# Technical Note 1

**Project:** Alston Dairy, Preston Road, Longridge

**Subject:** Response to Highways Consultation

**Date:** 21<sup>st</sup> May 2024

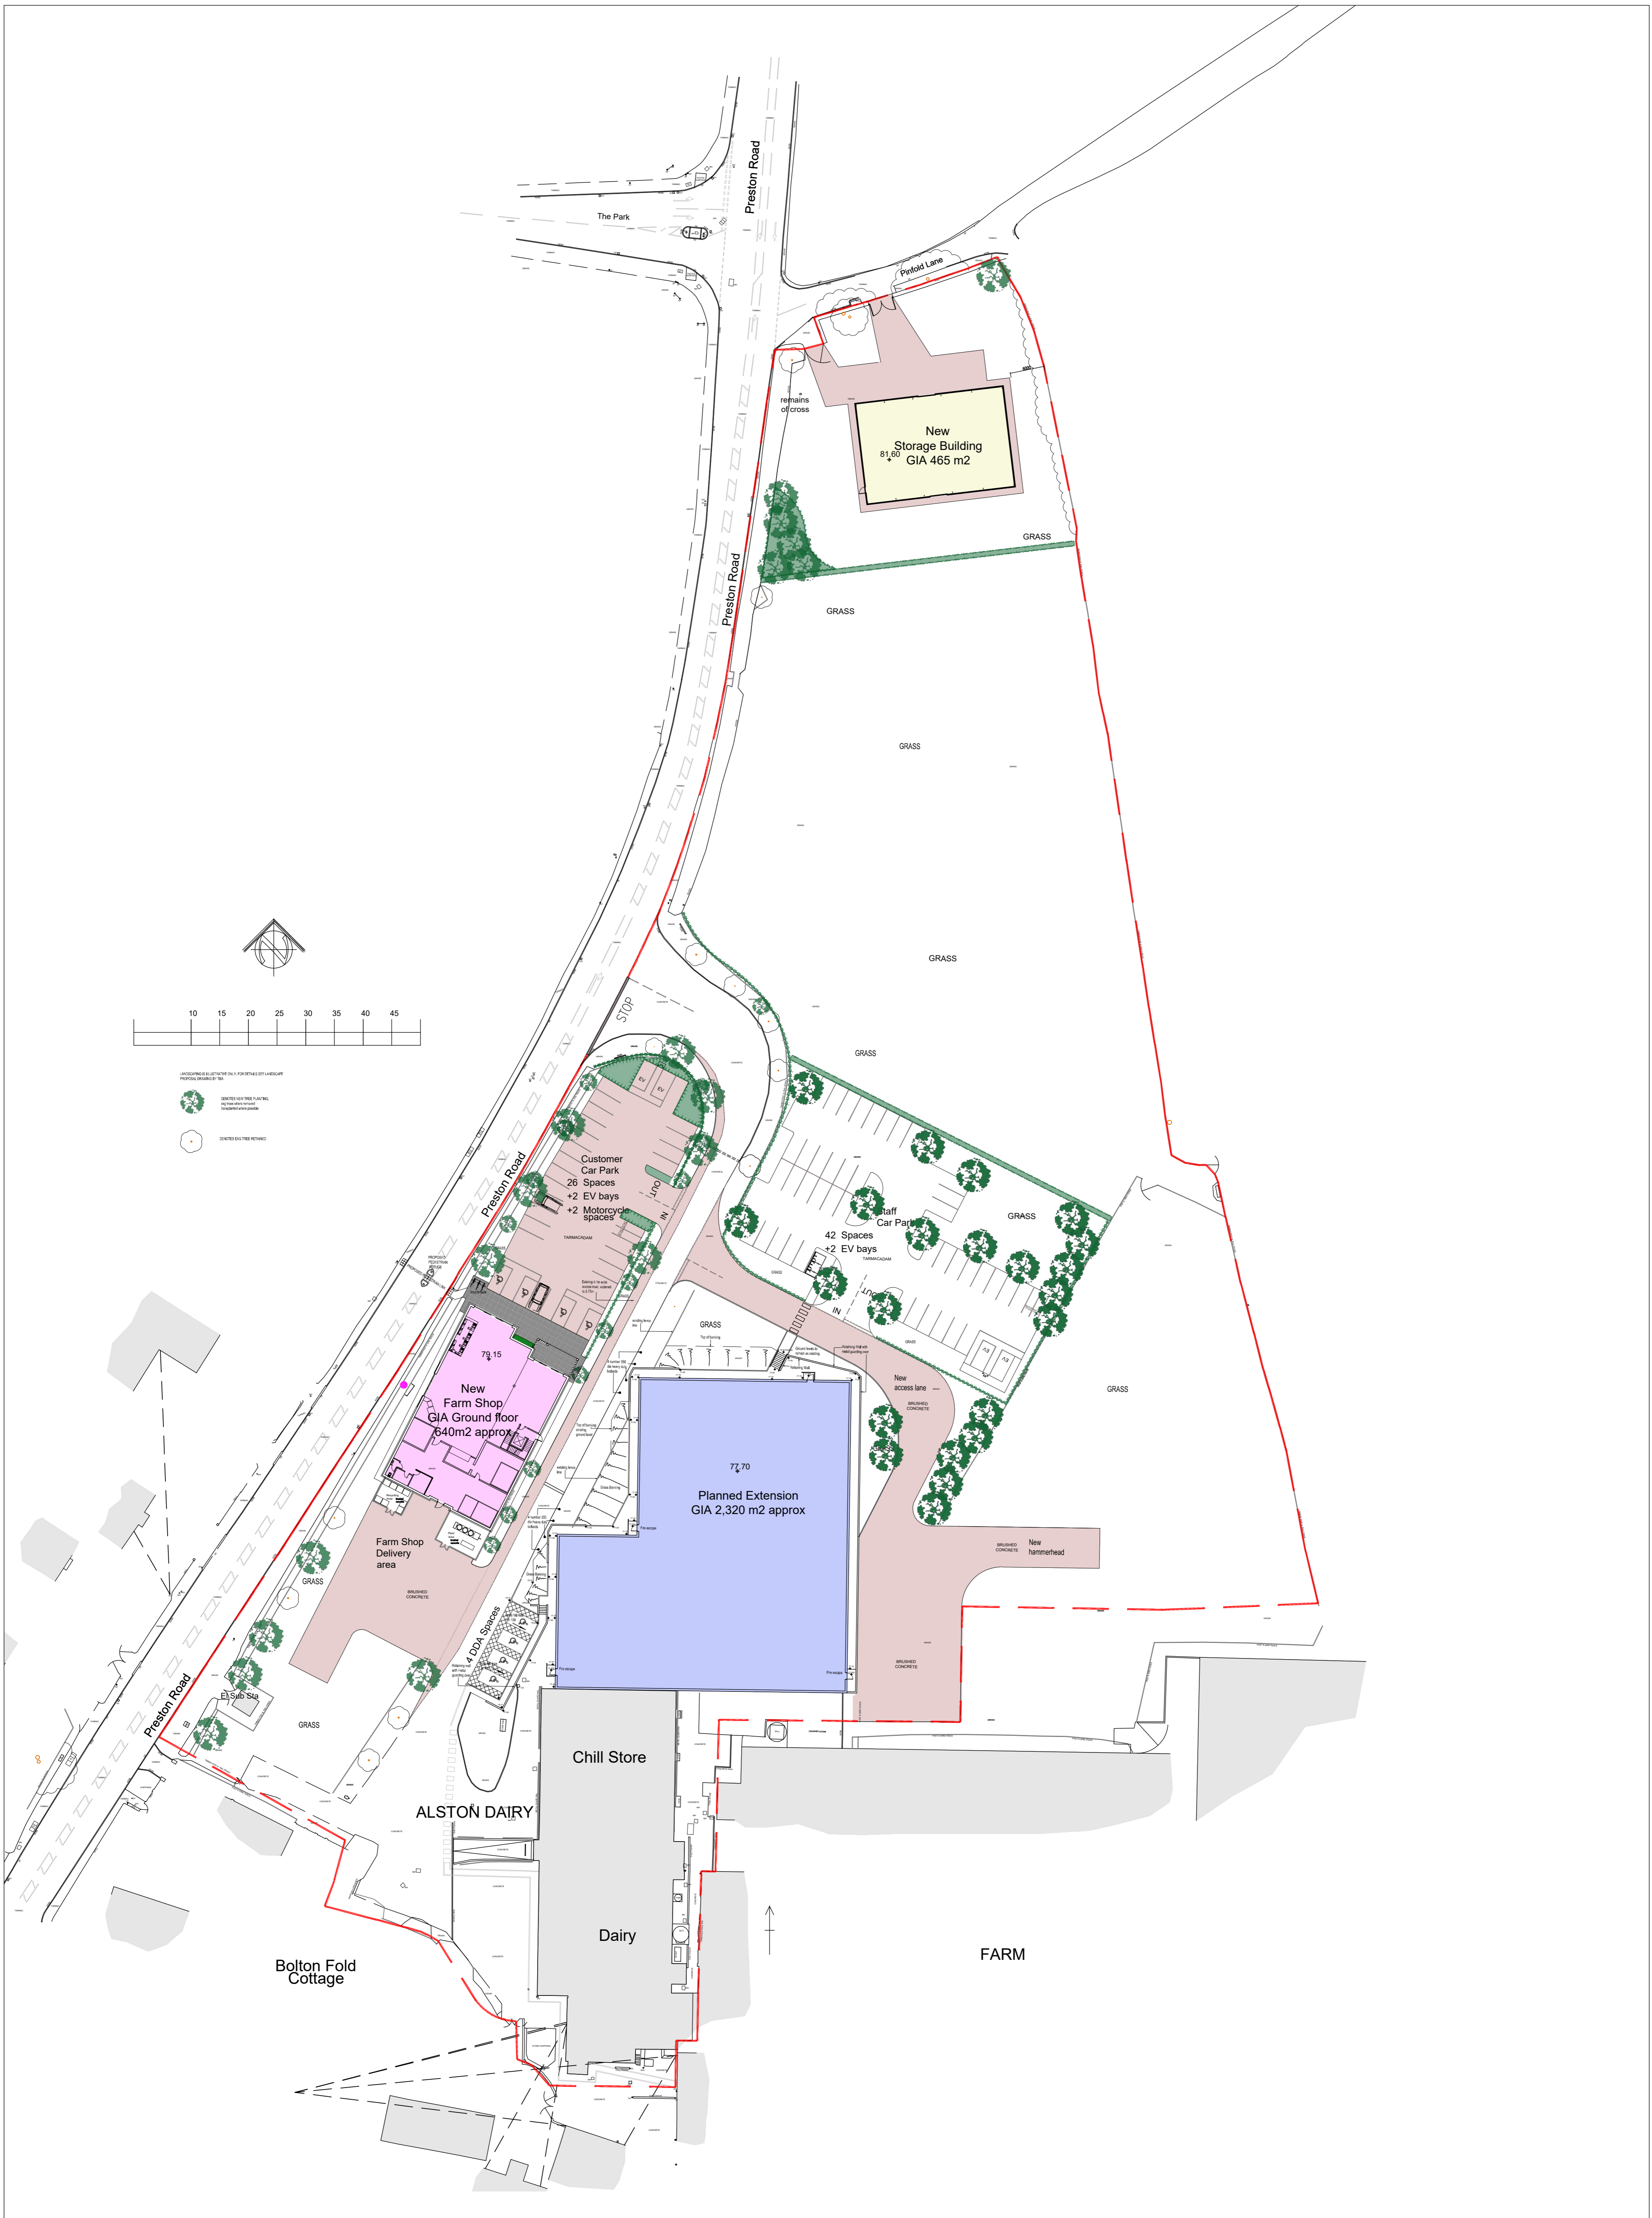
The LHA have reviewed HWL drawing number PL-05 Rev R4 titled "Proposed Site Plan" and note that the proposal will utilise the existing access to serve the proposed farm shop and cafe along with the extension to the dairy warehouse. However, as presented within the Transport Statement, the site is expected to generate 92 two-way movements during the AM (0800-0900) and 84 two-way movements during the PM peak (1700-1800). As well as 84 two-way movements during the Saturday peak (1200-1300). While the LHA require further information regarding where this trip data has been generated from, with the Transport Consultant stating that the trip rates have been derived from "experience of working on other sites for the Applicant." As presented, given the expected trips the site will generate during peak hours, the LHA require further carriageway widening along Preston Road to incorporate a full right turn lane into the site.

The LHA require the right turn lane on Preston Road to be a minimum of 3.5m wide, while both running lanes need to be a minimum of 3.25m wide. The widening of Preston Road can be achieved by setting back the site access further into the site to allow for this localised carriageway widening. The LHA will also require a splitter island to be provided above the right turn lane to protect right turners from any overtaking vehicles. The splitter island will have a dual use, with it being used as a pedestrian refuge connecting the existing footway along the western side of Preston Road to the site.

To connect the pedestrian refuge which will act as a splitter island to the site, the LHA require the site access to provide a 2m wide footway to the north. The footway should connect to the proposed pedestrian refuge and be provided up to the farm shop and the staff car parking area. The LHA require an internal footway to be provided to ensure that there is a segregated pedestrian link to and from the site with the site generating a significant number of trips from vehicles of all sizes.

To the south of the site, as shown on HWL drawing number PL-05 Rev R4, a pedestrian refuge along Preston Road which will connect the site via an internal pedestrian link to the existing footway along the western side of Preston Road has been proposed. However, some further localised carriageway widening will be required to ensure that each running lane is a minimum of 3.9m wide. This again can be achieved by setting everything back further into the site.

The LHA will also request that the closest bus stops located adjacent to and opposite the Public House, the White Bull Inn are relocated further northwards due to there being localised constraints associated with the bus stops. The LHA will request that these bus stops are relocated adjacent to and opposite the dwelling named "Rose Villa." Each new bus stop should have as a minimum a flag and pole and bus boarder kerbing.

24. LCC have requested an improvement to the existing right turn to provide a minimum width of 3.5m with minimum running lane width of 3.2m together with a splitter island to protect right turners. 'Drawing No T4213-H-01 – Proposed Ghost Island Junction' as been prepared (**Annex 6**) which illustrates these improvements, and the Applicant has confirmed that he is willing to amend the proposals to include these.
25. LCC also requested that this splitter island be dual use and also provide a pedestrian refuge and crossing point however, this it is considered preferable in safety terms to have a single pedestrian refuge/crossing point located to the south of the right turn lane at the pedestrian entrance to the site (see below) and this is also illustrated on the above plan.

27. LCC have requested that the carriageway is widened locally to provide 3.9m running lanes to either side of the kerbed island. The Applicant has confirmed that this will be provided and the 'Drawing No T4213-H-01 – Proposed Ghost Island Junction' has been updated to illustrate this.

28. LCC have requested that the closest bus stops located adjacent to and opposite the Public House (the White Bull Inn) are relocated further northwards to a pointy adjacent to and opposite the dwelling named Rose Villa. In addition, each new bus stop should have as a minimum a flag and pole and bus boarder kerbing together with a new 2m wide footway along the eastern side of Preston Road to link the site to the bus stops for pedestrians.
29. The Applicant has confirmed that these will be included and the 'Drawing No T4213-H-01 – Proposed Ghost Island Junction' has been updated accordingly.

35. As discussed at the meeting, the possibility of staggering the internal farm shop and dairy staff car park entrances has been investigated and this is now shown on the proposed Site Layout Plan.
36. It was also agreed that the internal footway along the SW side of the farm shop building would be extended to the service area with a pedestrian route then marked to the disabled spaces adjacent to the factory entrance. This has been incorporated into the proposed Site Layout Plan (**Annex 8**)
